9 July 2011

WEST KEIRA DEVELOPMENT, WOLLONGONG

Following receipt of a further set of preliminary amended drawings for the above proposal, I have reviewed them in relation to the heritage impact statement I prepared in July 2007 for the original development application.

1 ELEVATION
KEIRA STREET
1:200 @B1

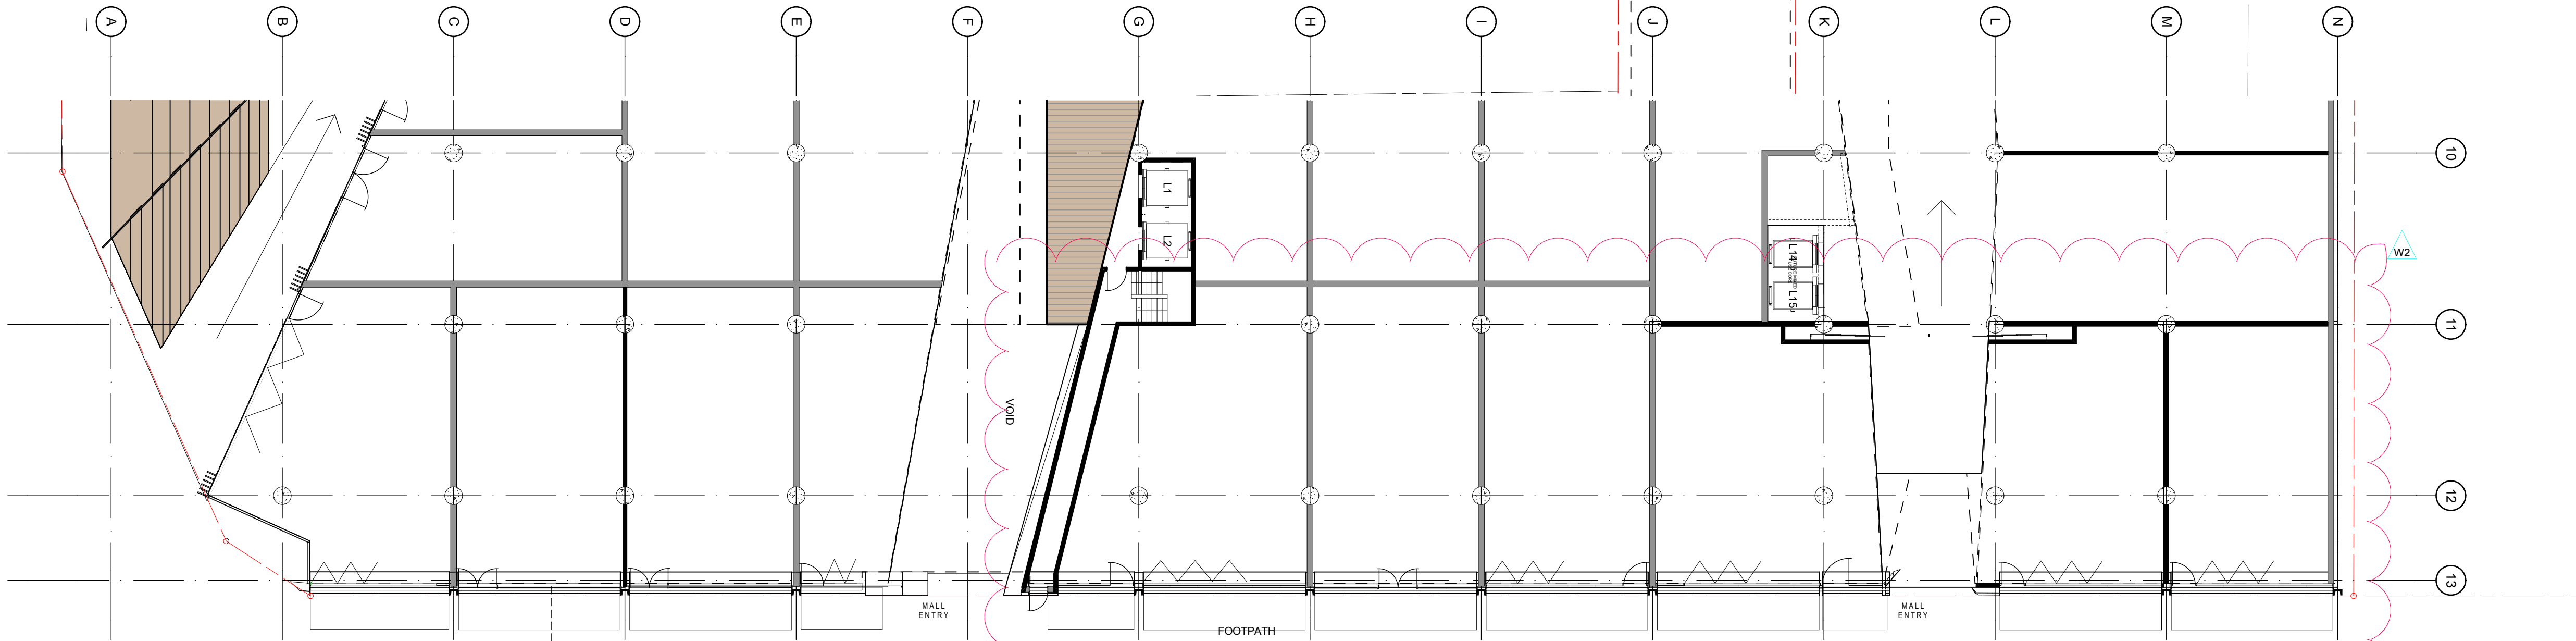
The drawings indicate that a courtyard (shown as the South East Court) is to be created at the corner of Keira Street and Crown Lane, with the western wall at the edge of the courtyard on grid line 8, which corresponds to the eastern end of the existing building at the corner on the southern side of Crown Lane. Although few details of the buildings in the vicinity of the West Keira site are shown on the drawings, it appears that there is no proposal at this stage to demolish this building, which is adjacent to but not included in the heritage listed group, although probably originally of a similar age and design to the rest of the group, as noted on page 9 of the Heritage Impact Statement.

Having reviewed the above drawings, I can confirm that the conclusions and recommendations of the July 2007 Heritage Impact Statement remain largely unchanged. The horizontal setback of the street façade from the present corner of Keira Street and Crown Lane, resulting from the creation of the South East Court, will reduce the visual impact of this façade on the setting of the listed heritage group in Crown Street. It does not appear to me that the increase in the height of the West Keira podium façade to Crown Lane will interfere with the view of the listed group of shops from Crown Street, and its visual impact on the group would be further reduced if the building on the corner of Crown Street and the south side of Crown Lane is retained.

DRAWING TITLE:
OVERALL SECTIONS
SHEET 1

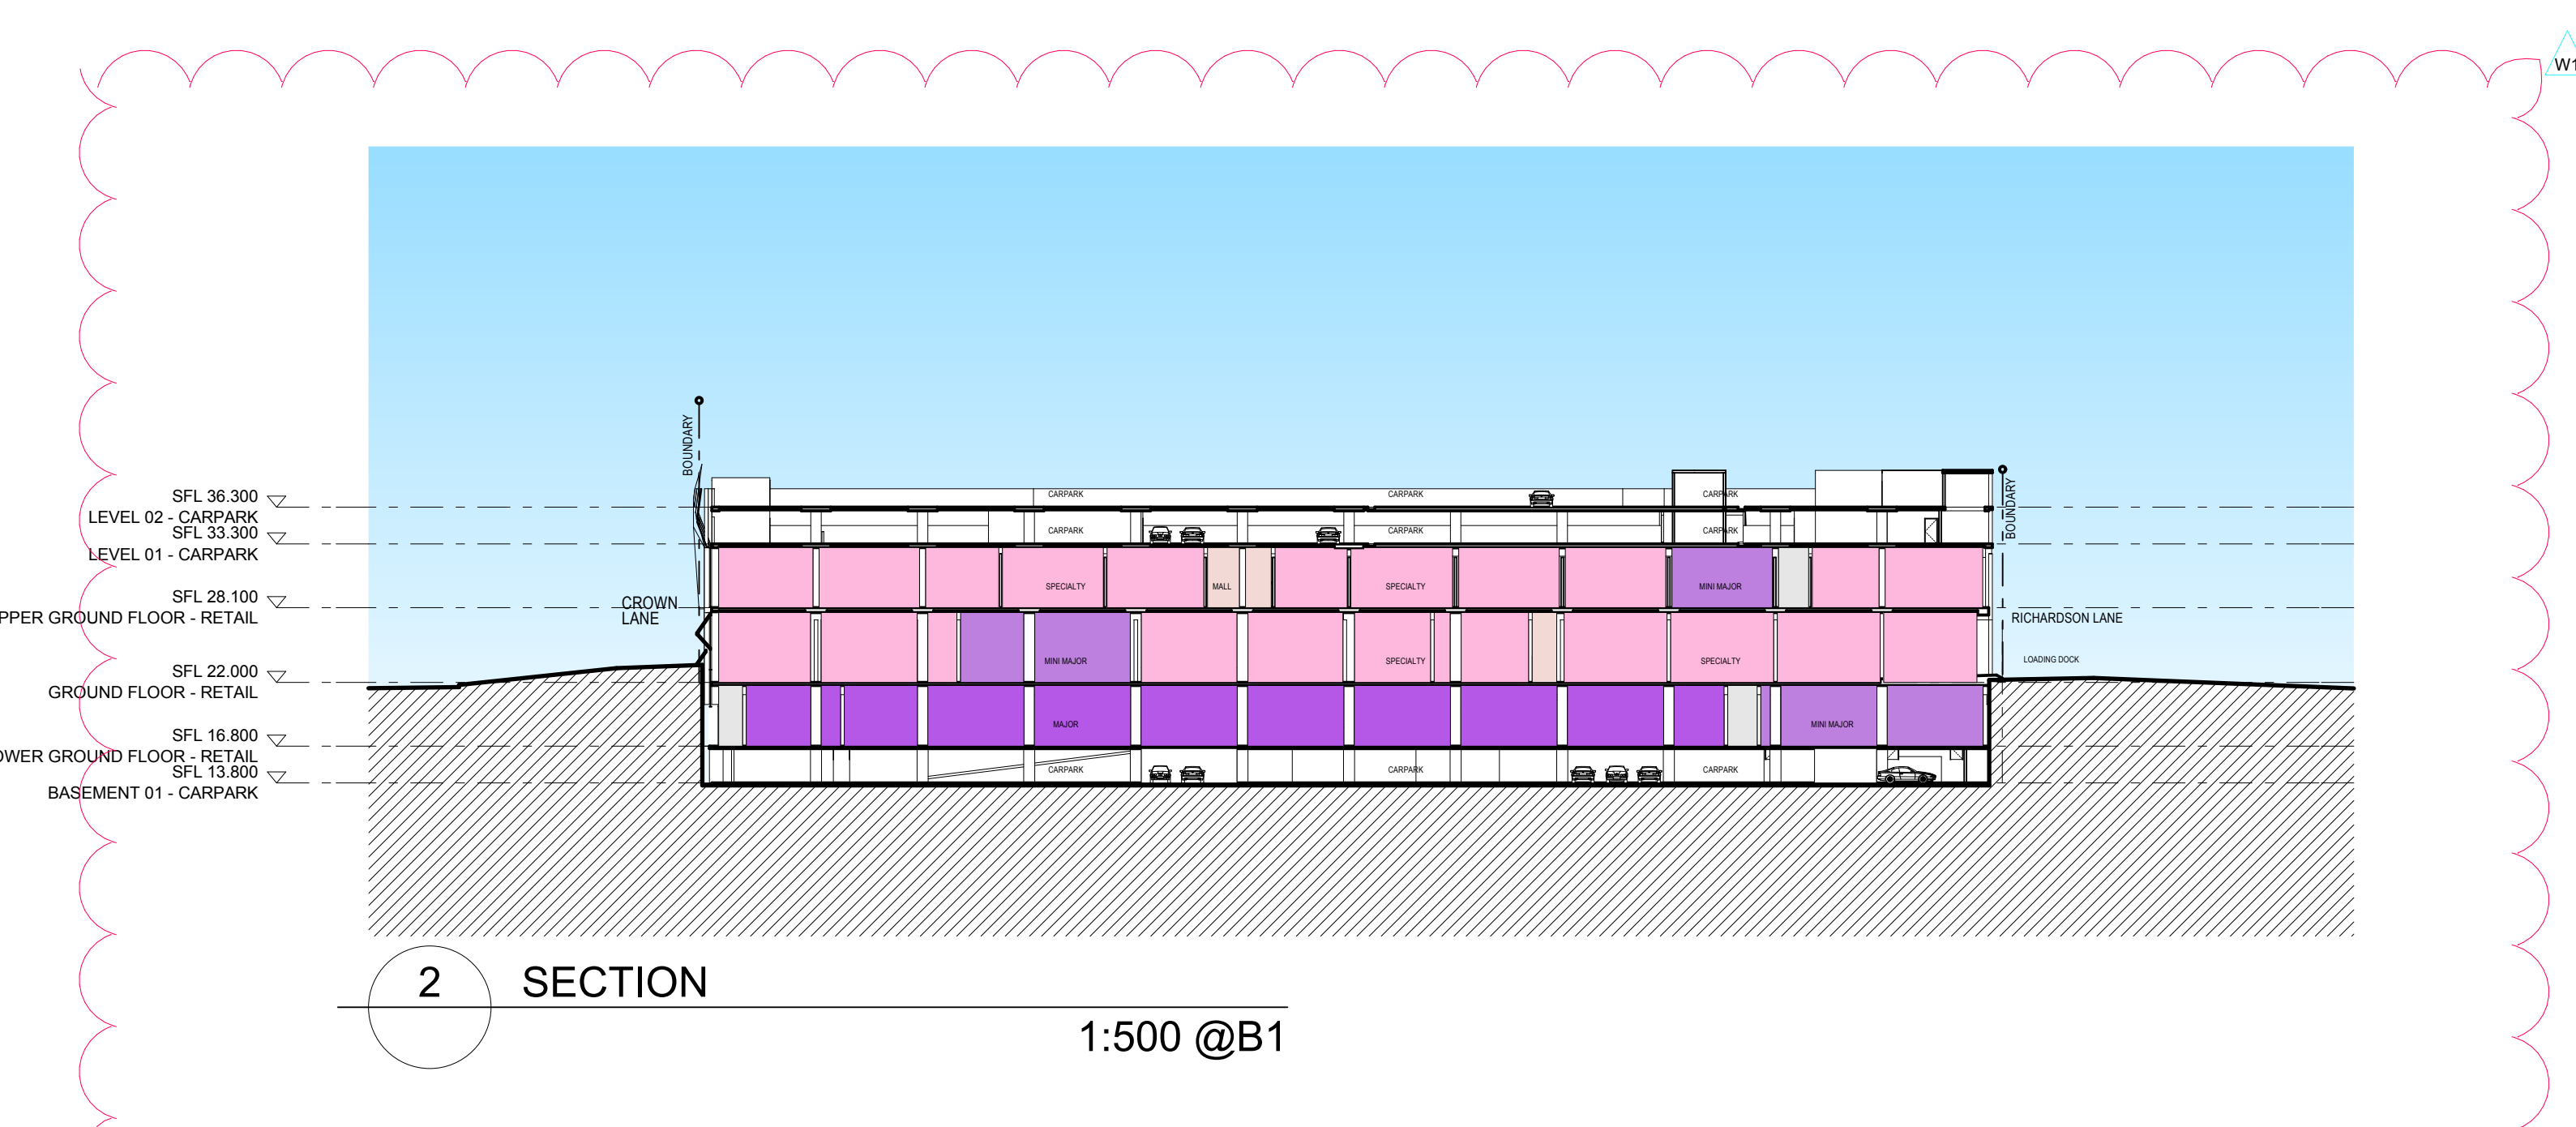
The drawings show the full height of the West Keira podium including the additional carparking floors to be constructed with the towers as part of a proposed Stage 2. Although the previous proposal did not show any detail of the Stage 2 podium extension, the drawings indicated (by dashed lines) that the extension was to be set back from the facade of the Stage 1 podium. The present scheme shows this setback occurring at a higher level, so that the eventual street façade will be of the order of 25m high at the corner of Crown Lane and Keira Street, compared with the previous proposal of approximately 18m in height at the same point. It is noted that the glazed upper wall of the façade is proposed to be "folded" along broken sloping lines that at their highest will be at approximately the same level as the top of the former Stage 1 façade.
